Our Ref: X12292

North West Rail Link – EIS 2
SSI-5414
Submission by Mulpha FKP P/L for Norwest Business Park

Figure 6.27 Bella Vista Station - Indicative layout

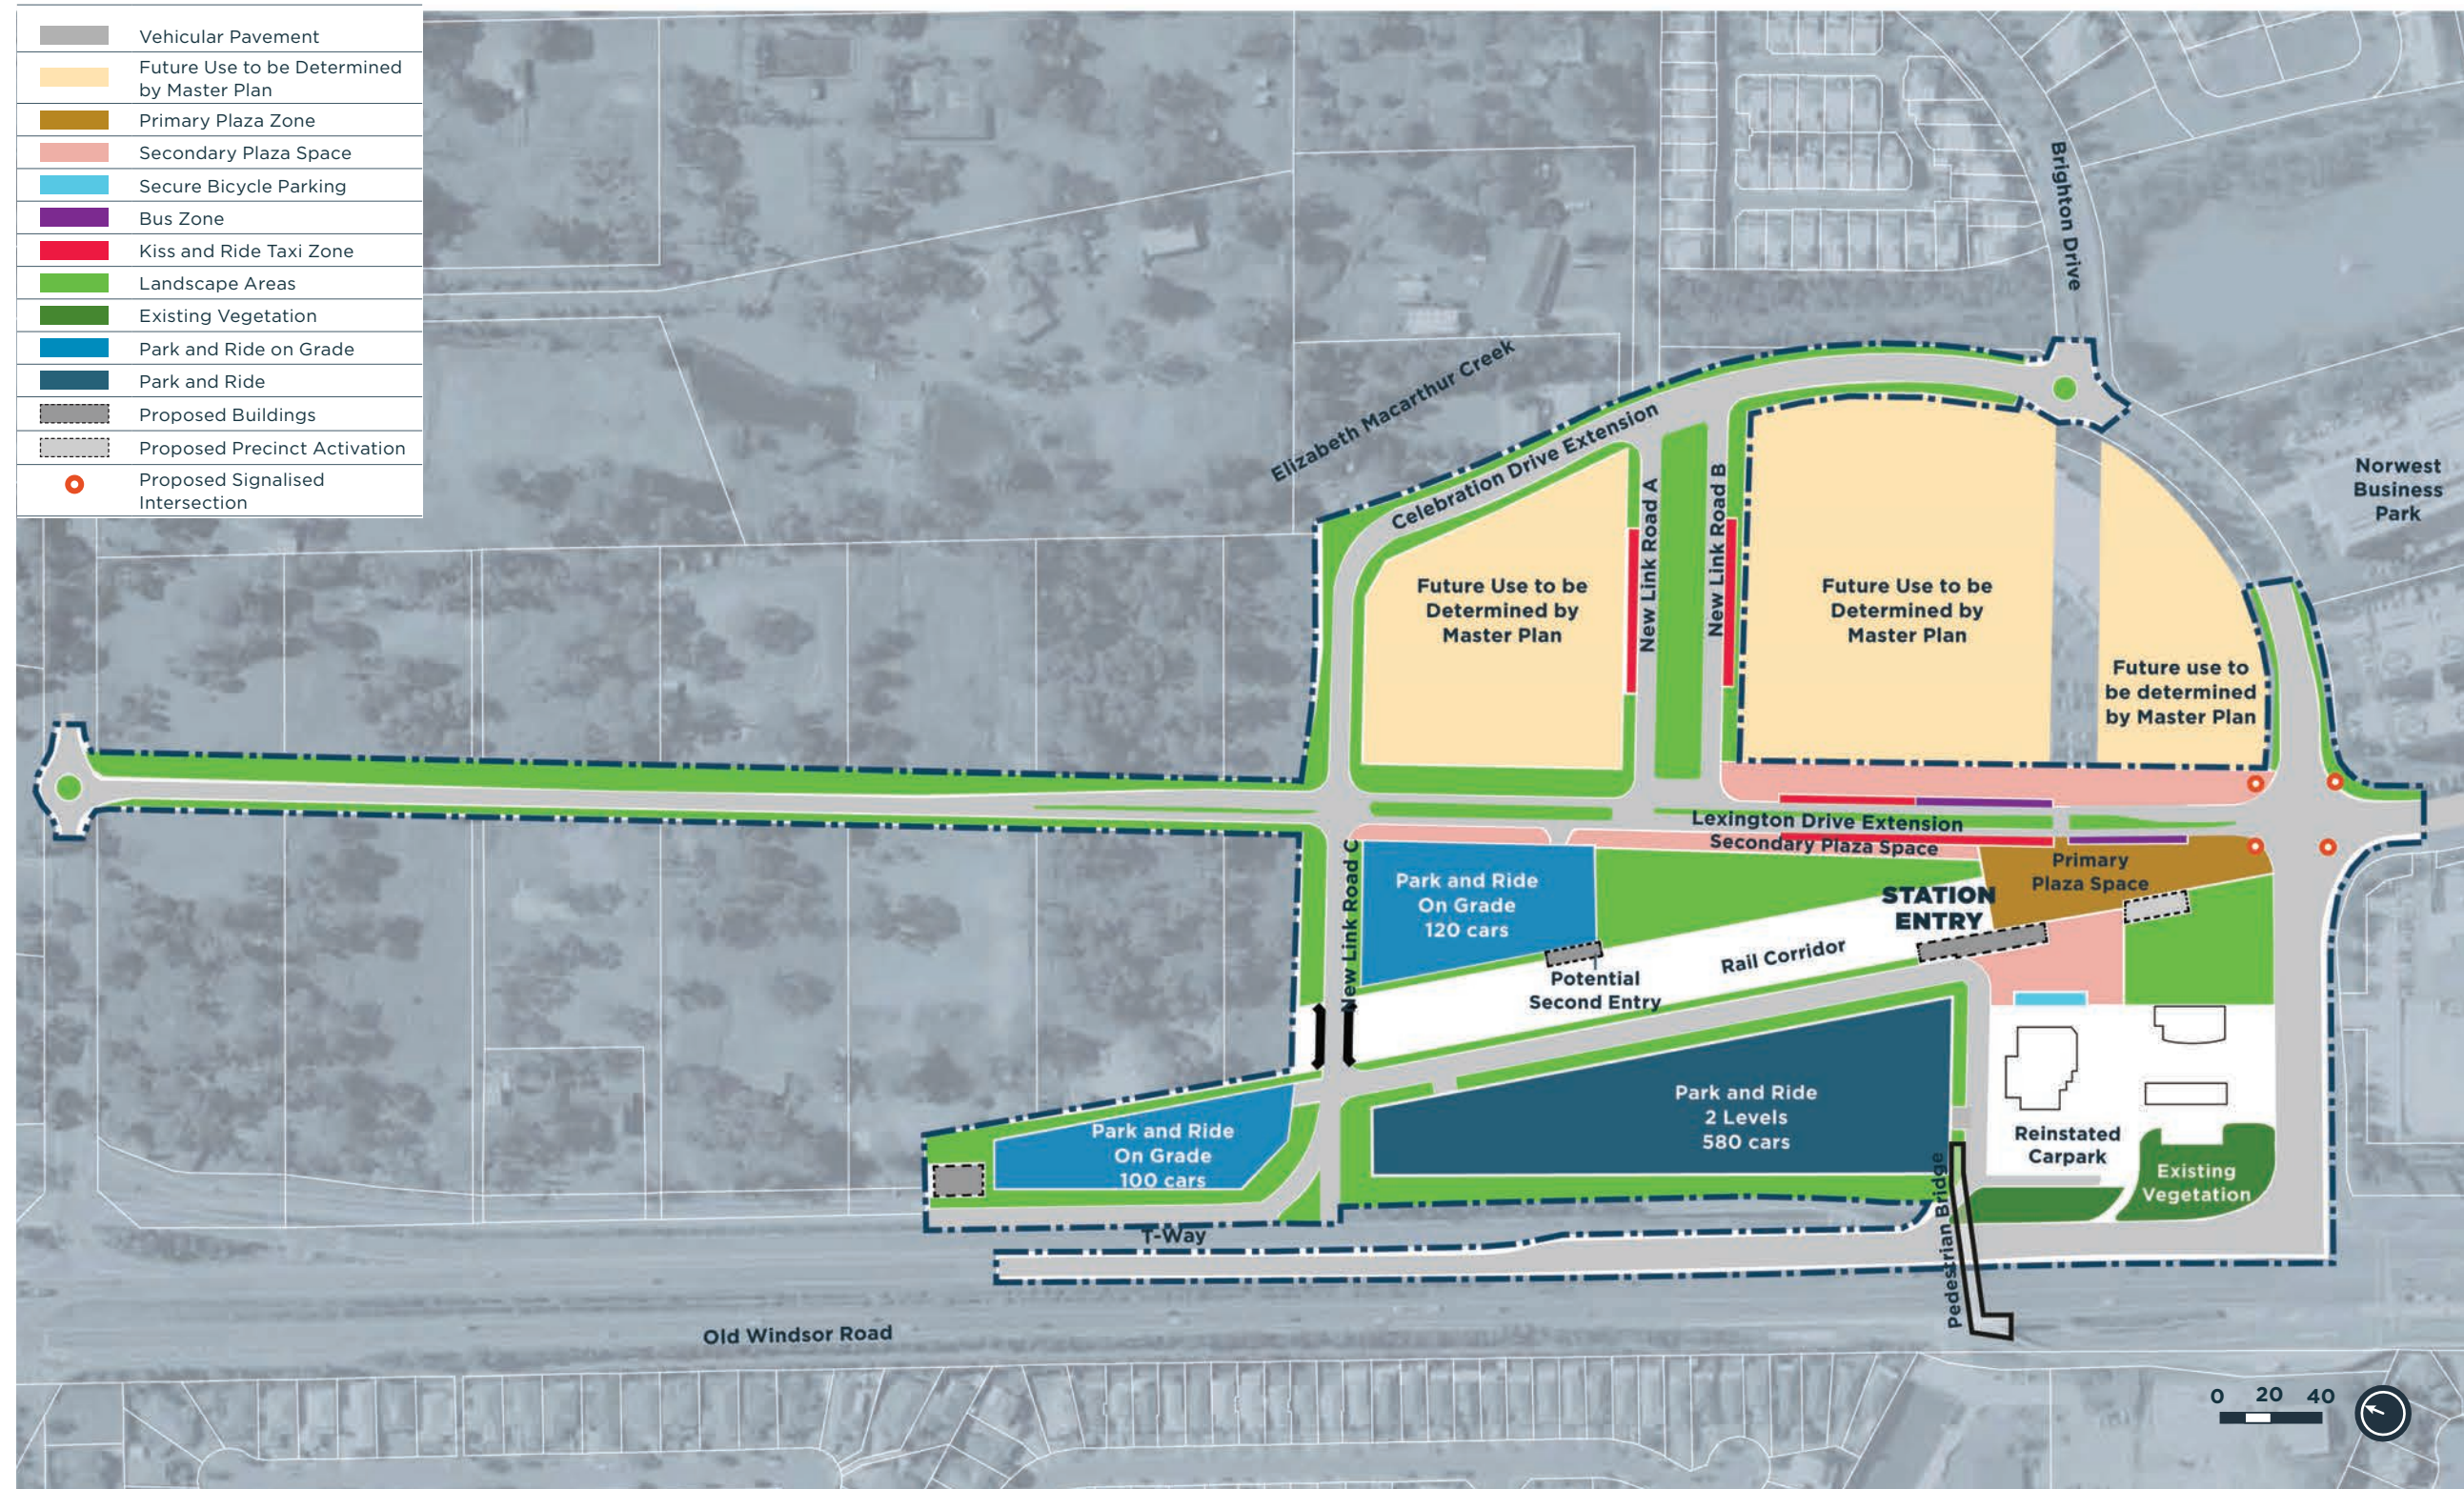
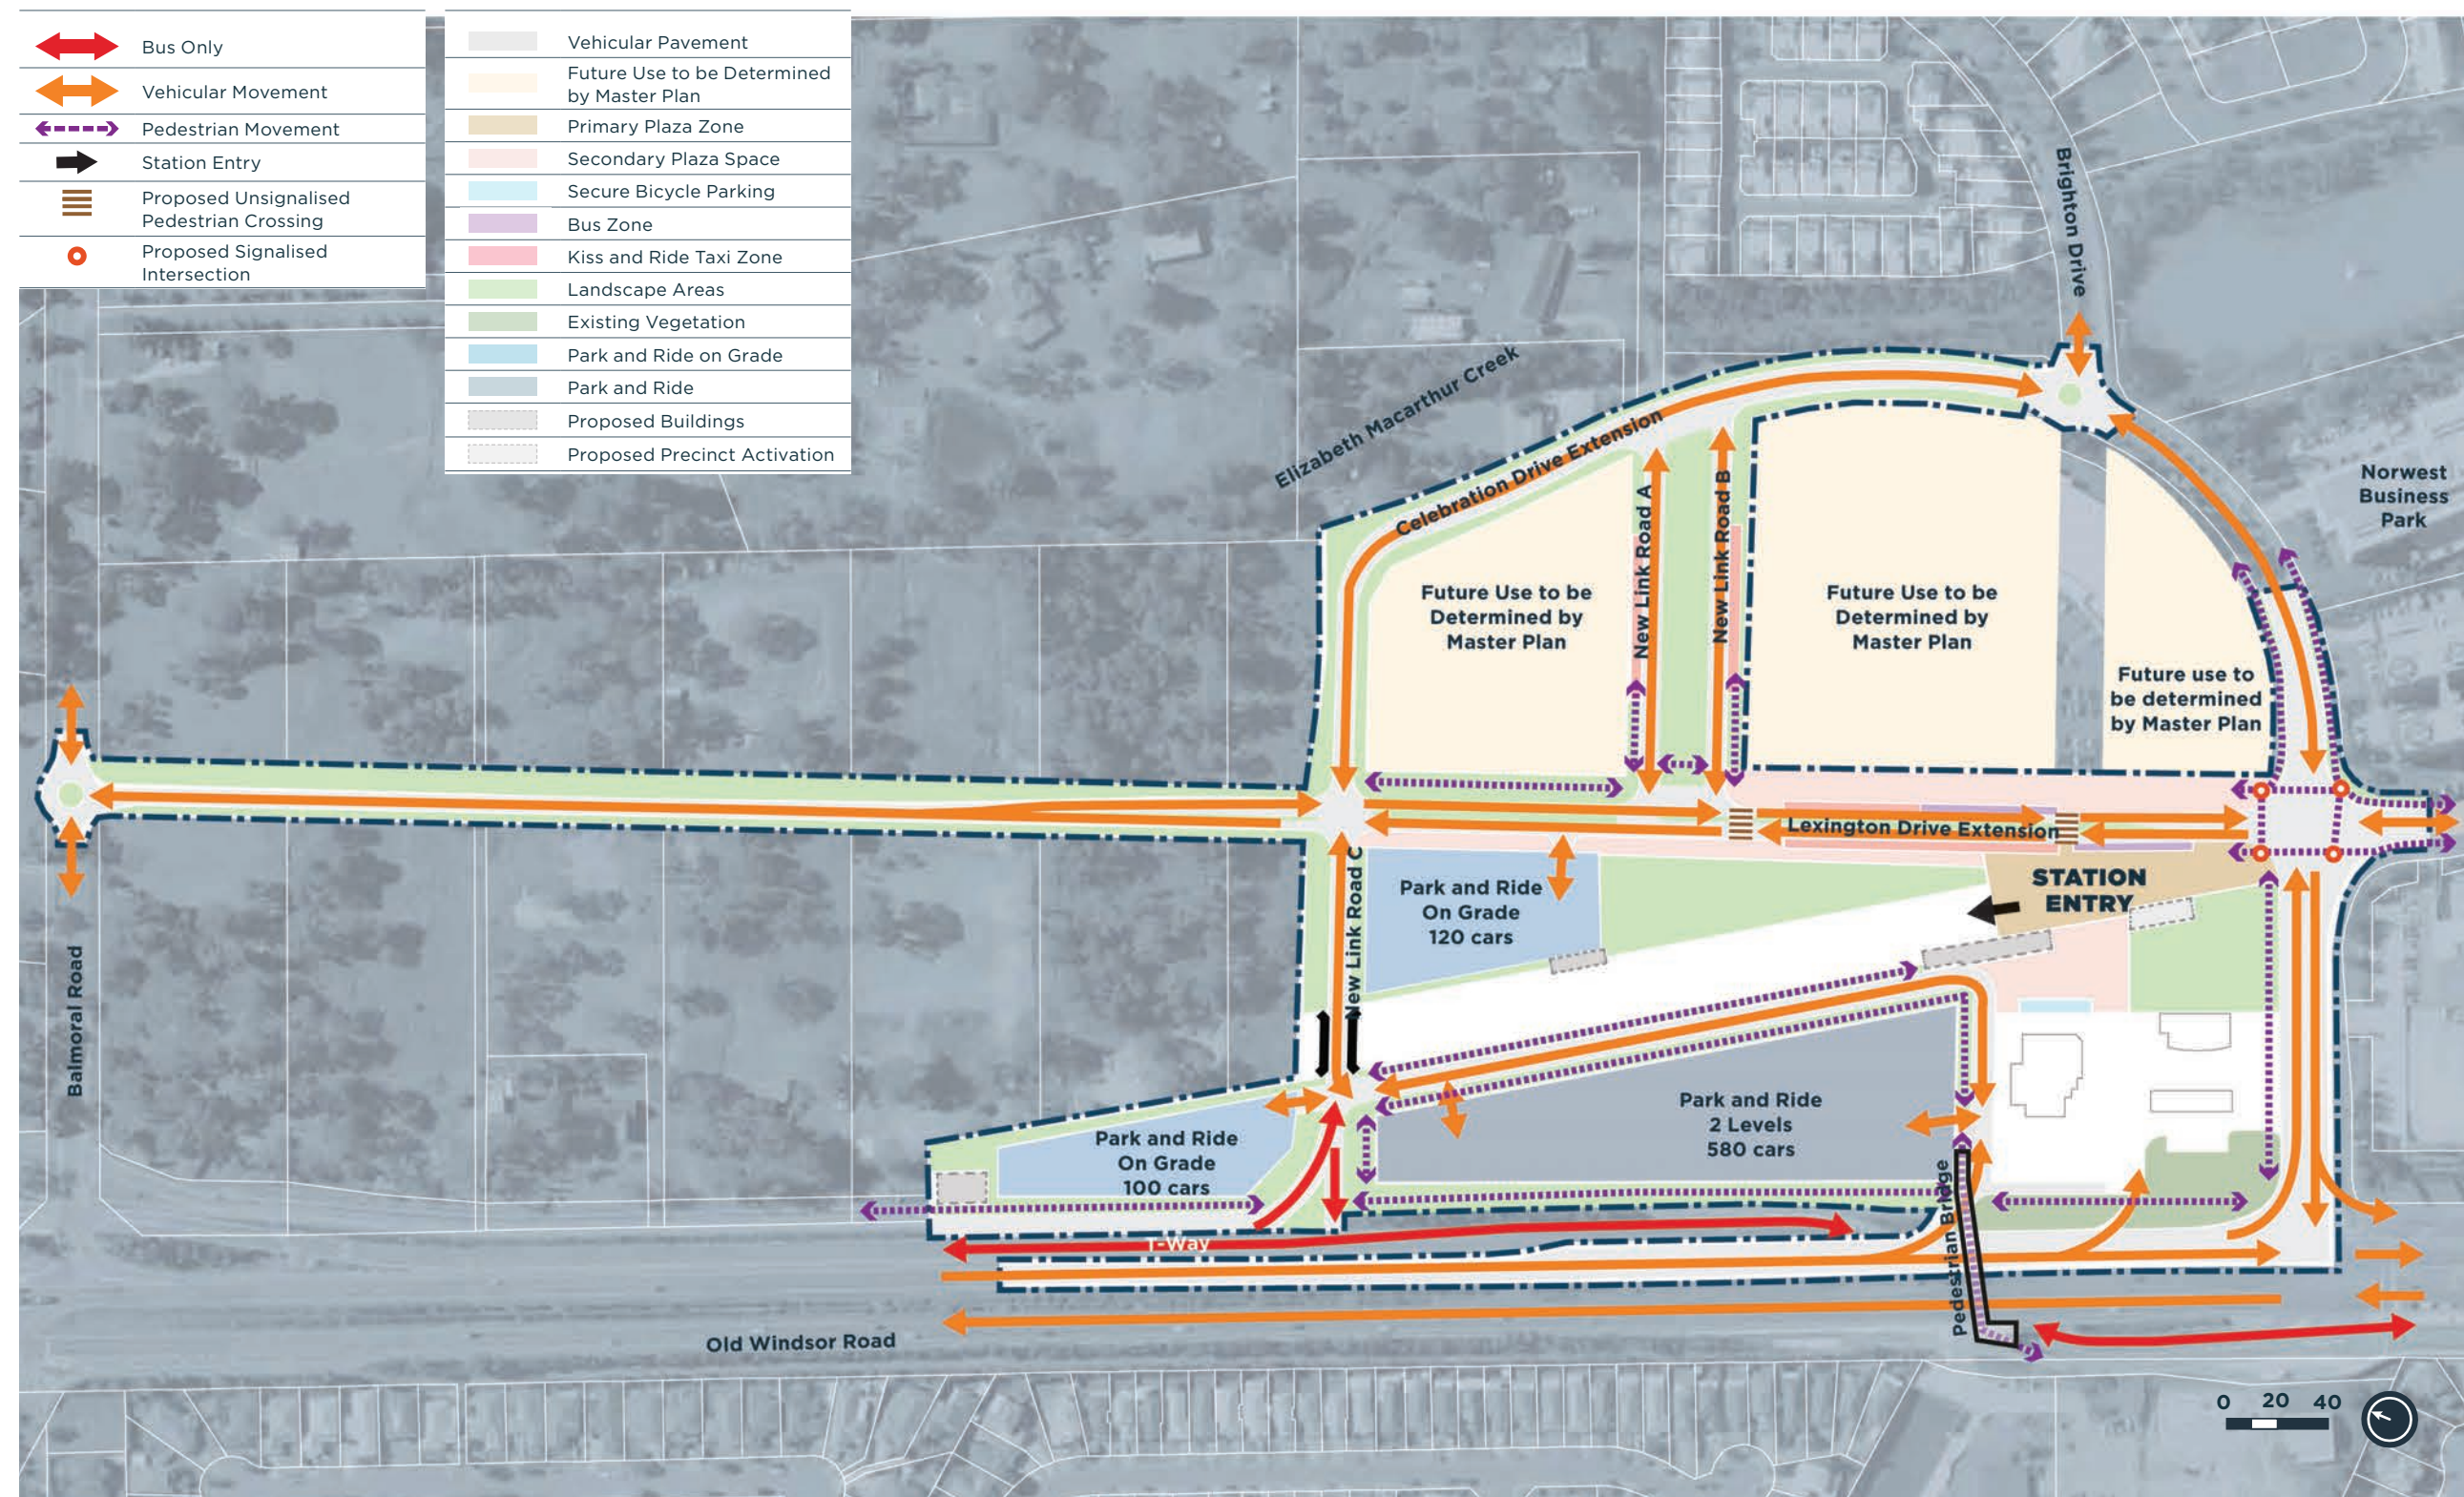
The focus for this station precinct is around an extended Lexington Drive with identified sites for future development as part of the master planning. The Bella Vista station plans show a new road parallel to Old Windsor Road that provides access to the station plaza entry. This new road is shown as connecting to Balmoral Road and would act as a major collector road to access the station entrance. The status of this new road being an extension of Lexington Drive is seen as questionable given that this road is not identified in either the Norwest or Balmoral Road Development Control Plans.

This new link road from Balmoral Road would attract a significant volume of traffic and is in a different location than the collector road that was shown in the existing DCP's for the subdivision pattern. The existing collector road runs parallel to Elizabeth Macarthur Creek with a connection to

The proposed road as an extension of Lexington Dr would provide undesirable depth for blocks to be redeveloped, as either commercial or residential development in the future. **The extension of Lexington Drive to connect to Balmoral Road is not seen as the best location for the collector road.**

The preferred location is for the planned collector road to connect from Balmoral Road via Celebration Drive to Lexington instead of an extension of Lexington Dr.
